Application no: **3/2023/0248**

Address: **Highfield Garstang Road Chipping PR3 2QH**

Proposal: **Proposed replacement dwelling.**

The Local Highway Authority have viewed the plans and highway related documents and have the following comments to make:

south elevation

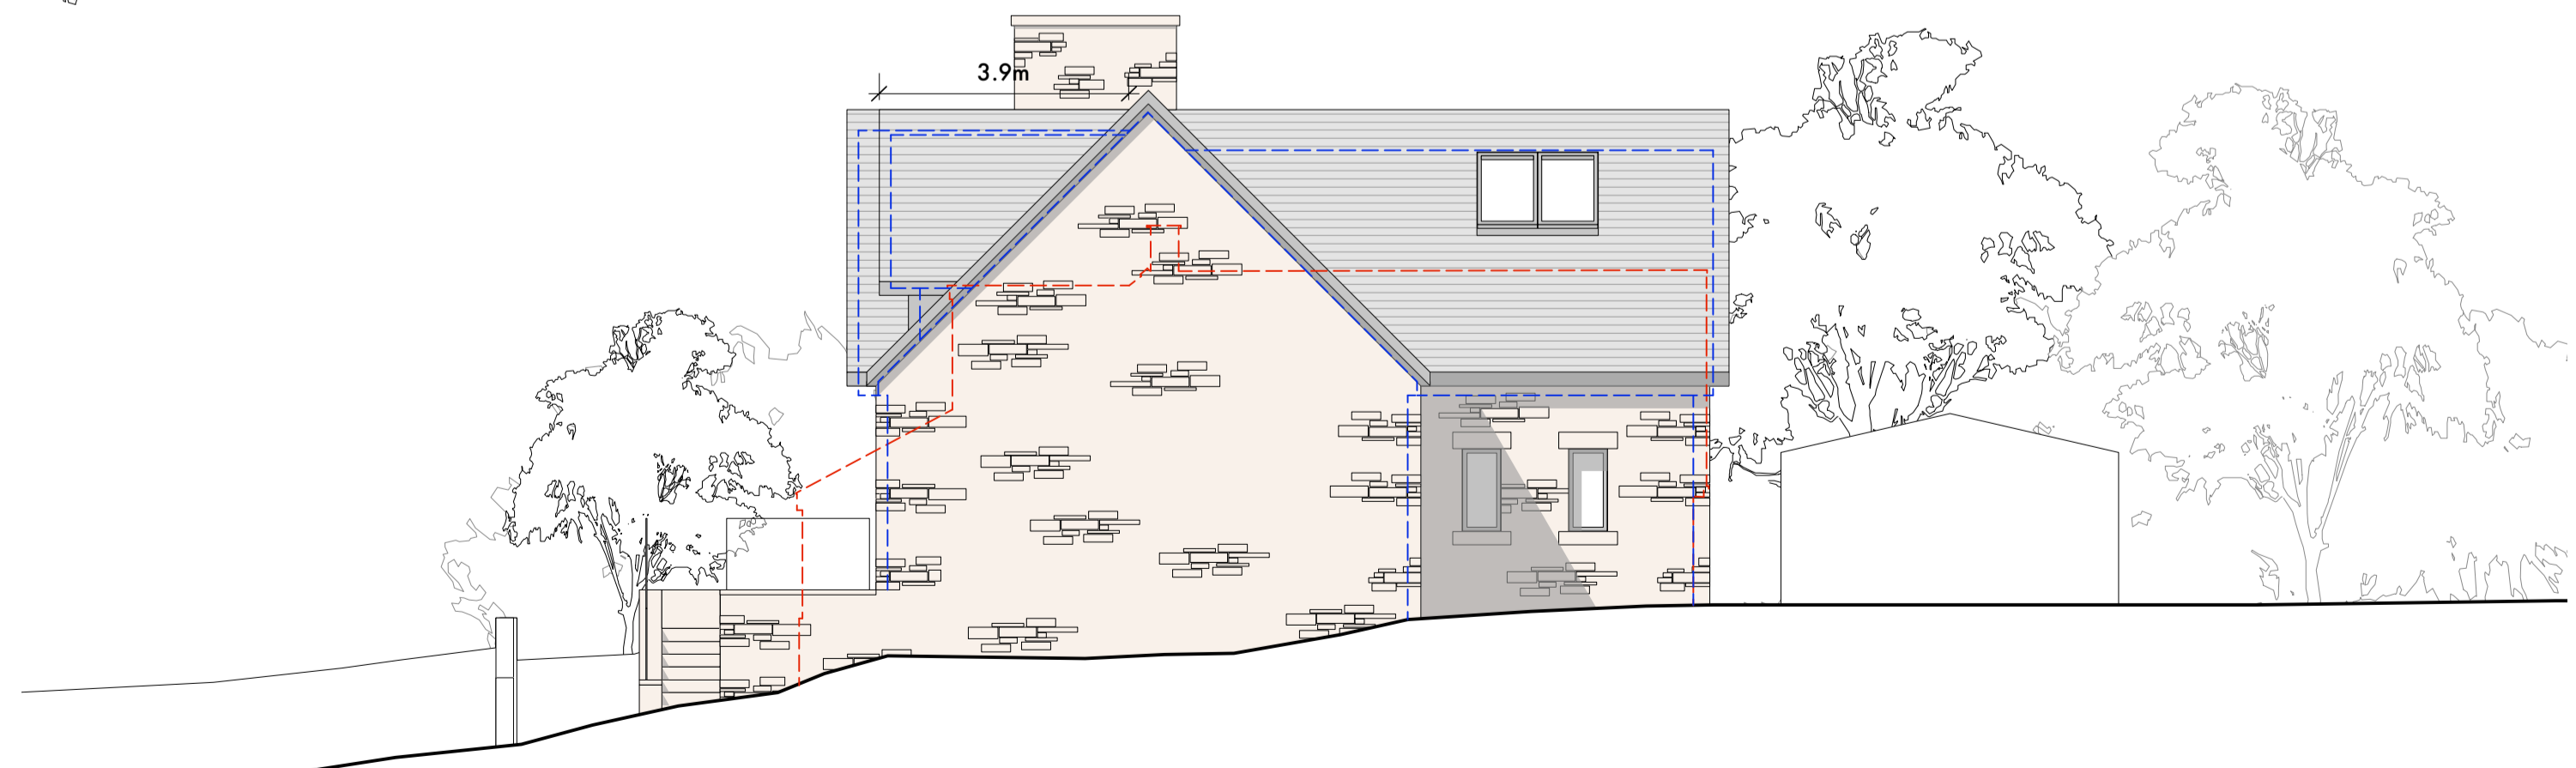
The LHA have reviewed Stanton Andrews drawing number PL.10 Rev B titled "Proposed Plans, Site and Elevations" and are aware that the proposed access arrangements will remain as existing. Therefore, with the access already serving the dwelling, the LHA have no further comments to make.

The LHA have reviewed Stanton Andrews drawing number PL.10 Rev B titled "Proposed Plans, Site and Elevations" and are aware that the parking arrangements for the 4-bed dwelling will remain as existing. Therefore, since the dwelling is already a 4-bed property, the LHA have no objection to the proposal.
